**FINAL DRAINAGE REPORT
ADDENDUM NO. 2
BENT GRASS RESIDENTIAL FILING NO. 1
FOR
BENT GRASS EAST COMMERCIAL
FILING NO. 3**

CCES Responses in red

PCD Filing No.: SP-20-010

Job no. 2177.64

|            | <b>BENT GRASS EAST COMMERCIAL FILING NO. 3</b><br>PRELIMINARY PLAN<br>PRELIMINARY GRADING PLAN |              |         |         |      |

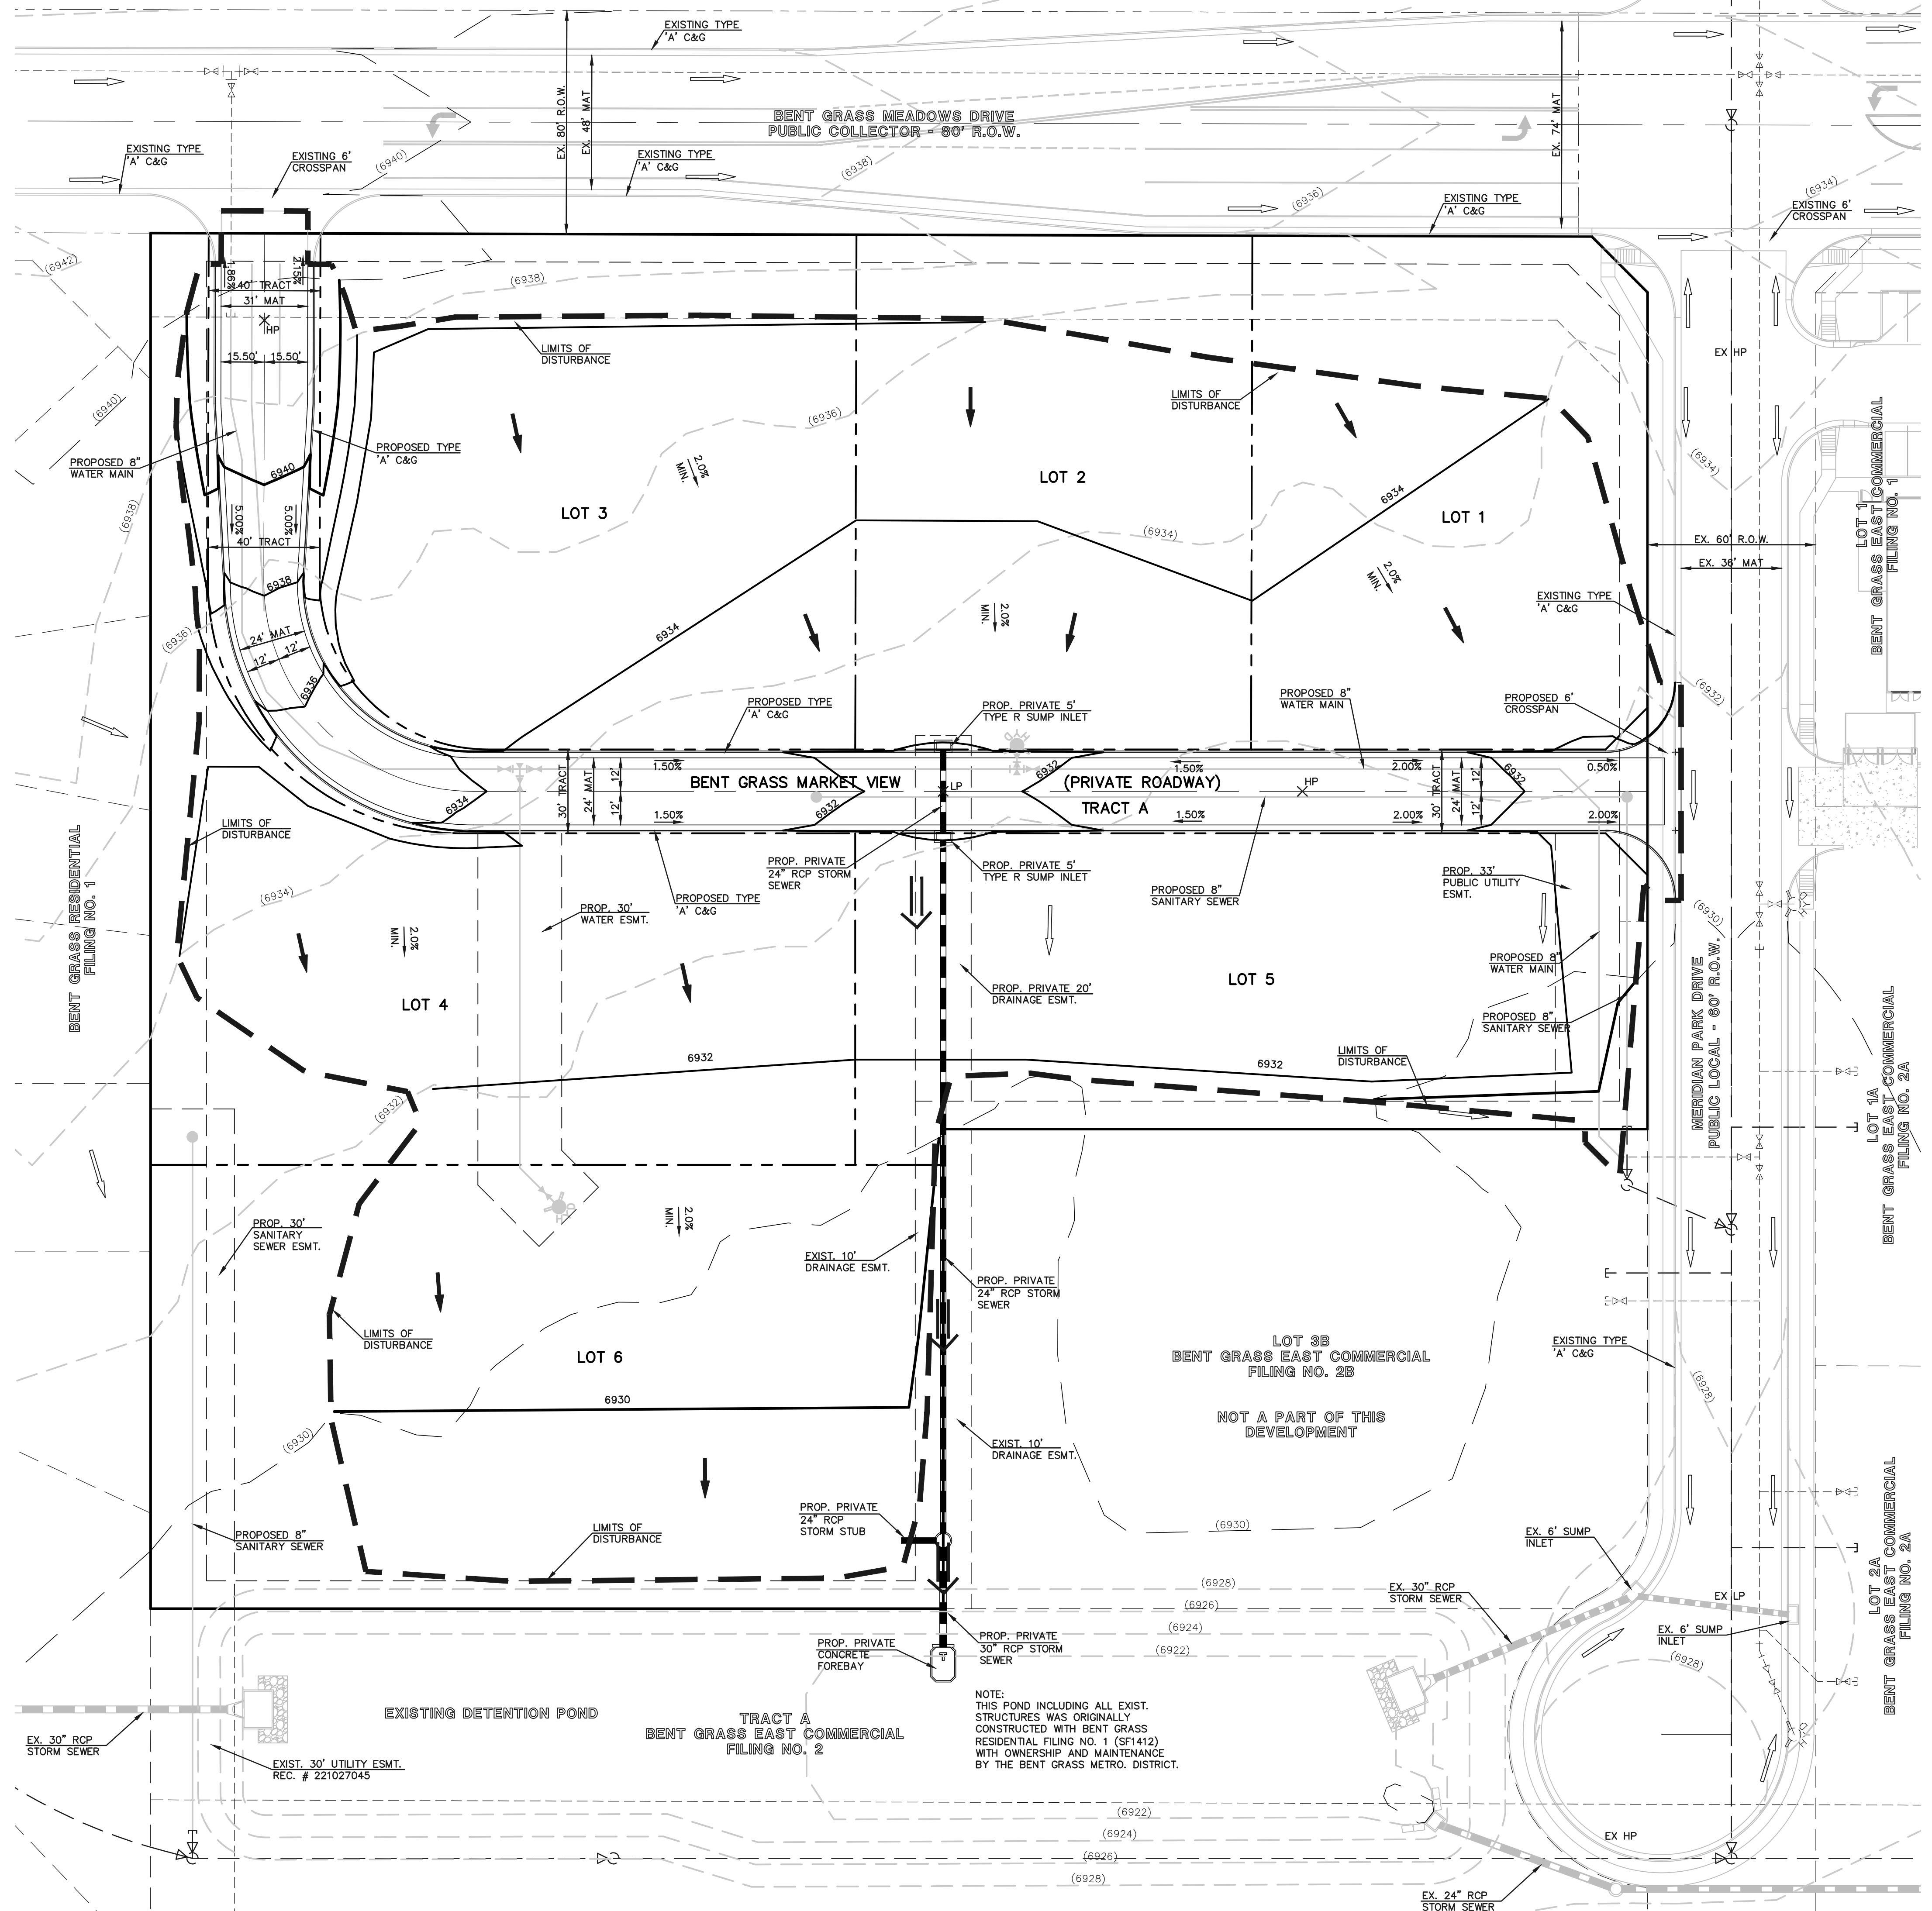
Per the drainage map, it appears that the majority of the runoff from basin C will sheet flow into the pond as opposed to being routed to the 24" RCP. Is the intent for the 24" RCP to be capped for connection by the developer of lot 6? Revise accordingly.

Please state whether the outfall of this flow is consistent with the previously approved report.

Please indicate how these flows are conveyed to the existing pond.

Per the provided drainage map this basin does not drain to the existing southerly pond. Per ECM appendix I, 100% of the development site must be captured. ECM I.7.1.C.1 allows for 20% not to exceed 1 acre of the applicable development site area to not be captured. If your intent is to use this allowance please state it in the report or provide another exclusion allowed per the criteria for not provided water quality for this basin.

Added additional clarification to the narrative

Added

Added additional narrative

Our intent was to use this allowance and additional language now added to the narrative
